**Re: Popeye's Restaurant, 10601 Central Ave. NE - Grading and Drainage Plan
Engineer's Stamp dated 7-27-05 (L21-D60)**

**Re: Popeye's Chicken, 10601 Central Ave. NE - Traffic Circulation Layout
Architect's Stamp dated 9-16-05 (L21-D60)**

**Re: Popeye's Chicken, 10601 Central Ave. NE - Traffic Circulation Layout
Architect's Stamp dated 9-9-05 (L21-D60)**

Re: Certification Submittal for Final Building Certificate of Occupancy for
POPEYE'S RESTAURANT ON CENTRAL, [L-21 / D60]
10601 Central Avenue NE
Engineer's Stamp Dated 12/07/20005

A1.0

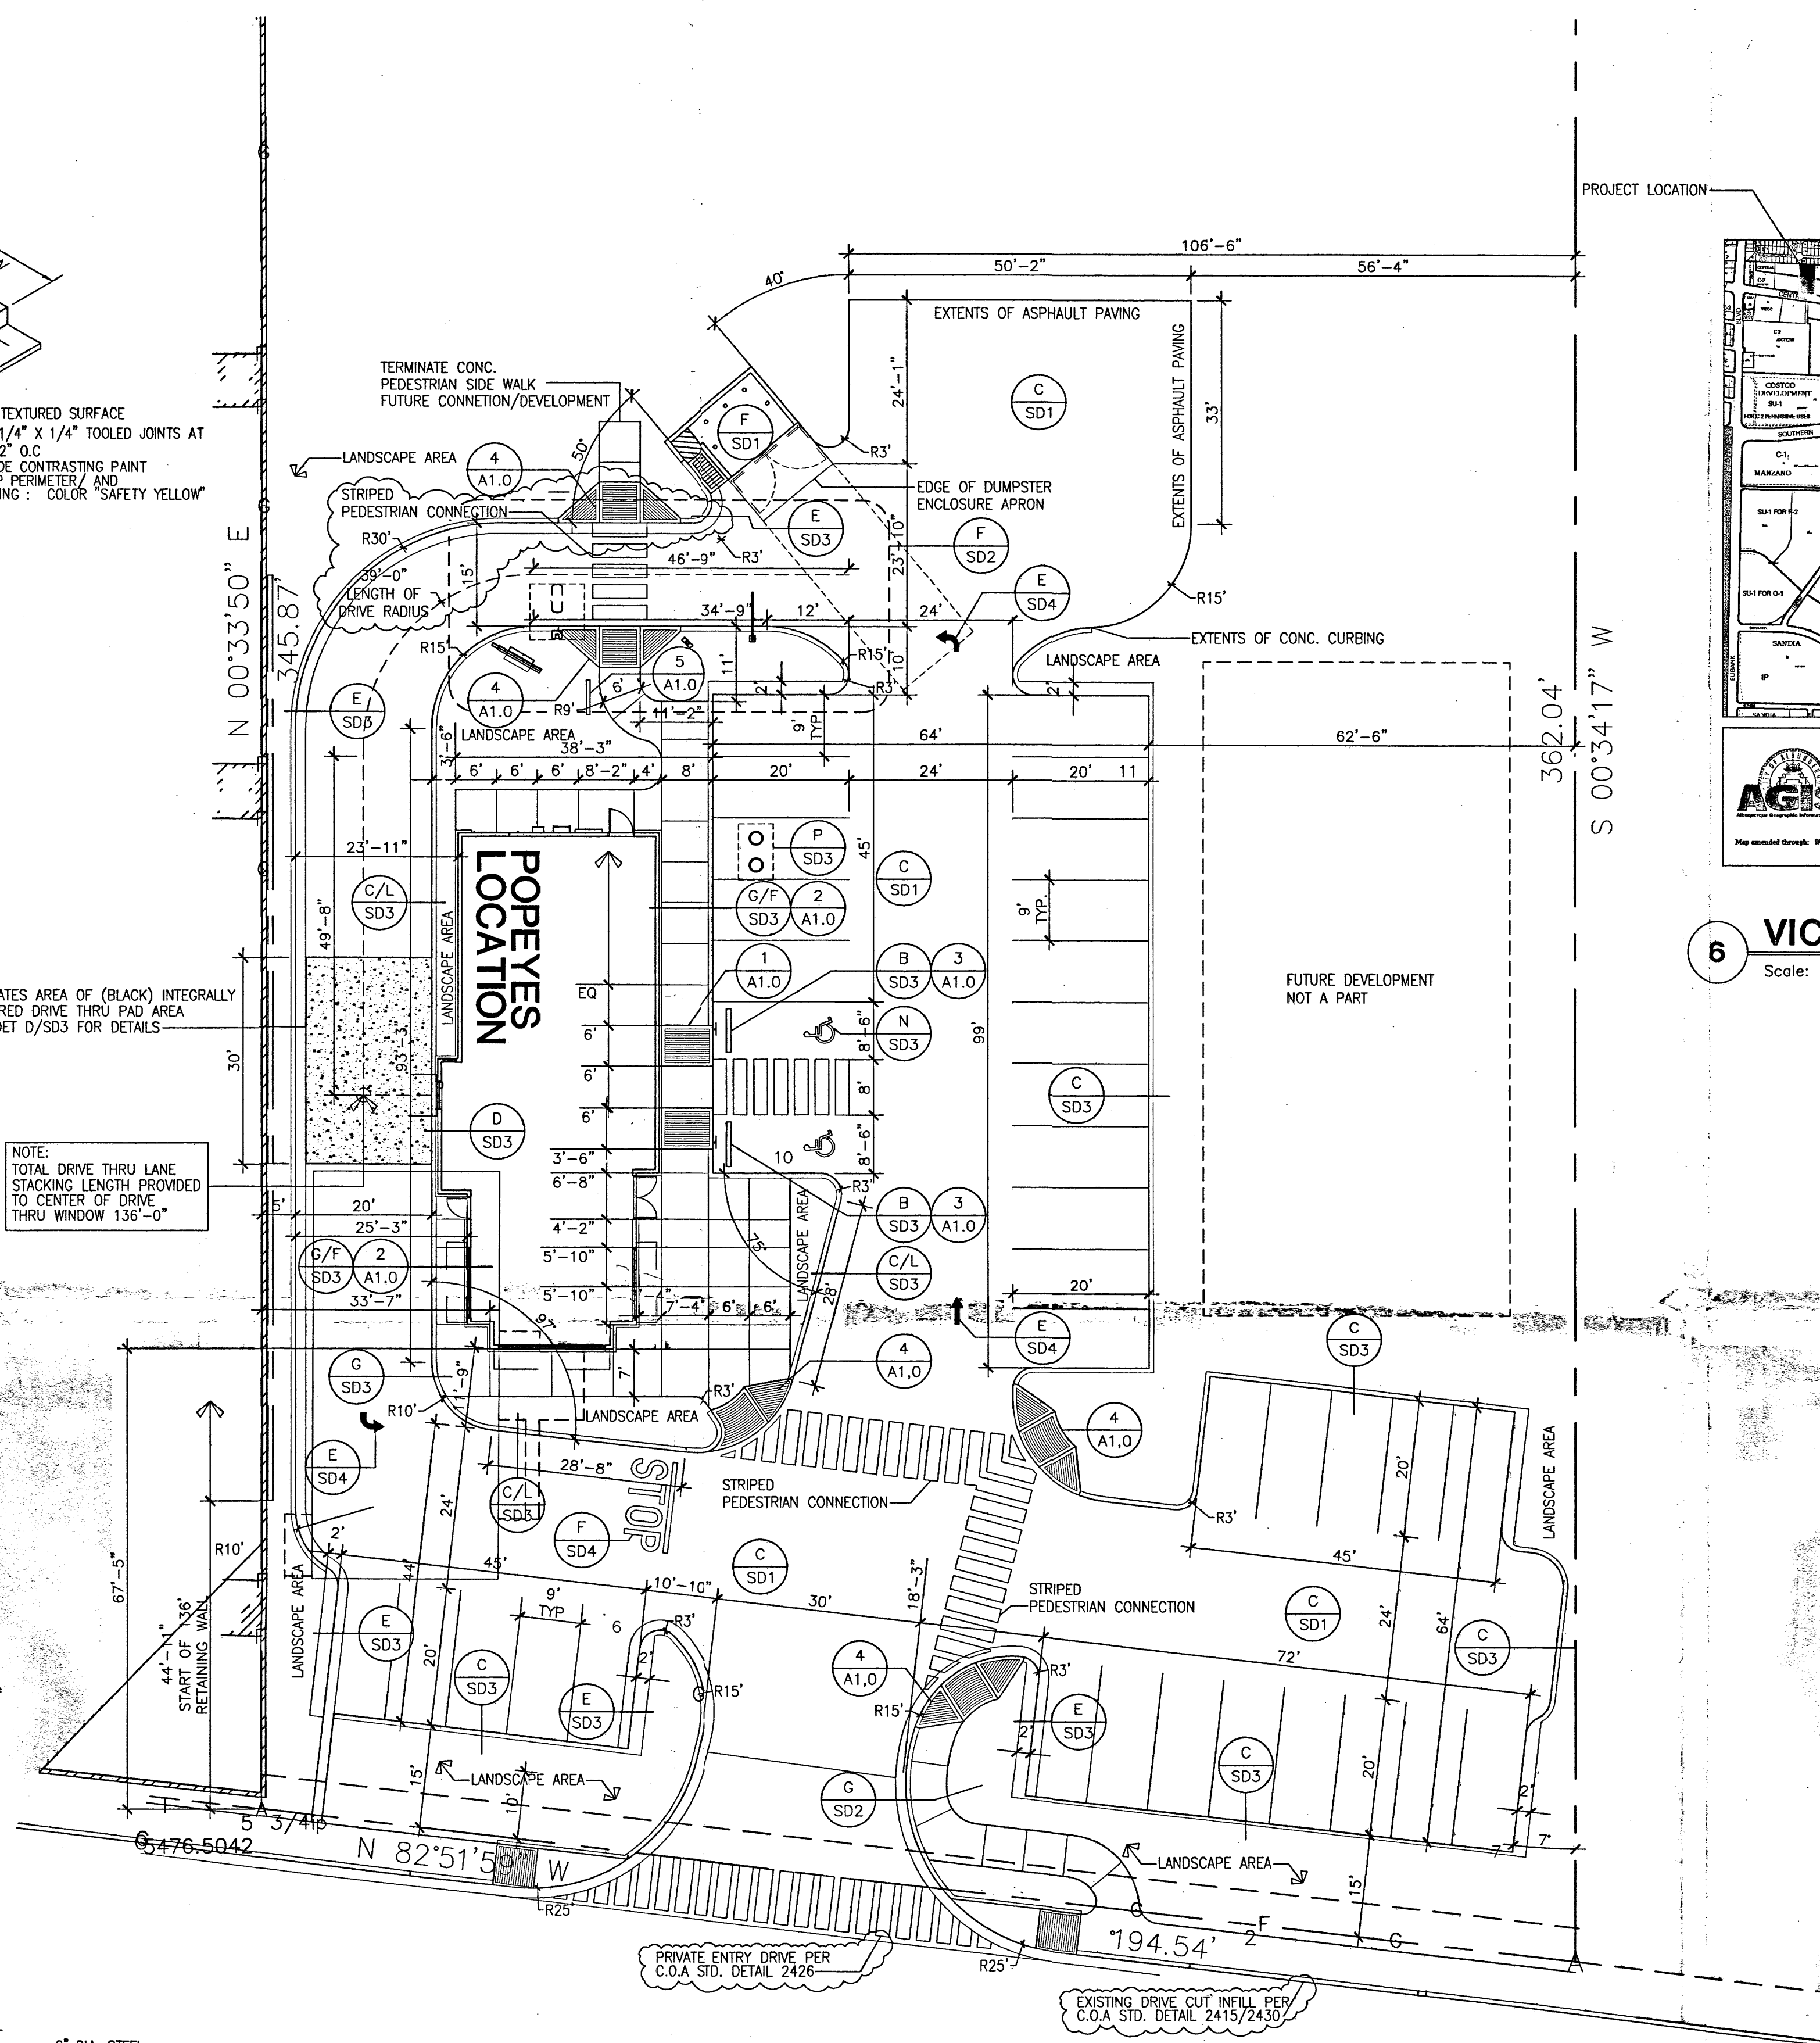
- Provide sidewalk easement.
- Provide parking calculations designating the number of parking spaces required by zoning as well as the number of parking spaces proposed.
- Provide Solid Waste approval for the dumpster location.
